Deeside Naturalists' Society

13 May 2026

Comments for deadline 6

Impact on Curlews and other birds using the 'functionally linked land'

**FIGURE TITLE**  
Curlew Habitat Creation and Enhancements

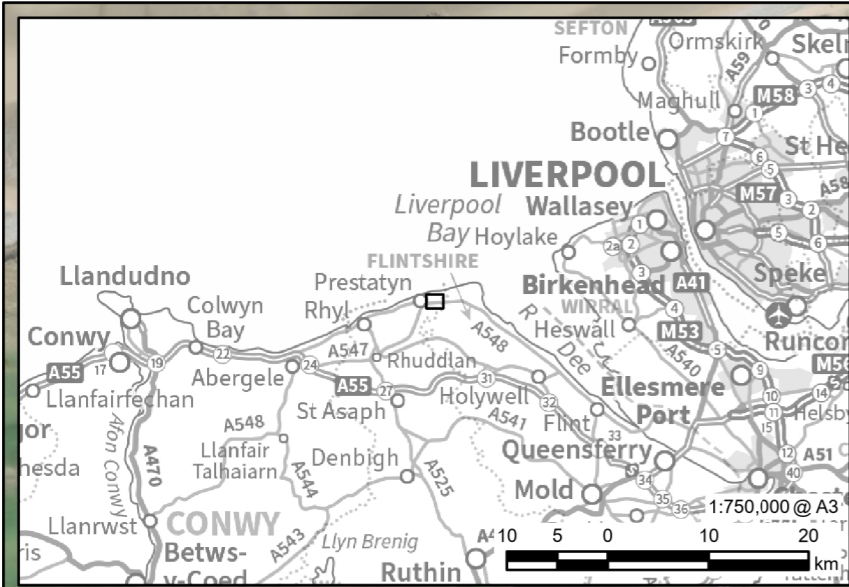
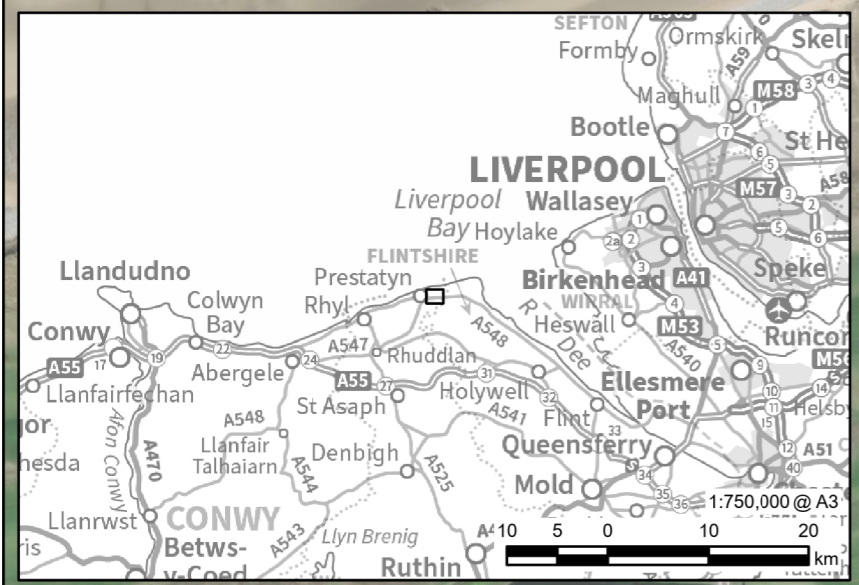
3. Uniper has acquired land at Gronant to deliver suitable alternative habitat for feeding Curlews. Considering the very limited options available to deliver alternative high quality Curlew feeding habitat within the Dee Estuary and we consider that is very likely the best option. We have made suggestions to Uniper on how the habitat restoration of this site can be enhanced to give the highest likelihood that these fields could regularly support at least 50 wintering Curlews.

Recommendation: Uniper's management plan for the Gronant site should focus on establishing seasonally flooded pools within the grassland utilising existing topography. Shallow excavation should be made (rather than creating foot drains) to create the pools. Grazing with cattle in summer and early autumn should be carried out to establish a reasonably short sward suitable for foraging Curlews.
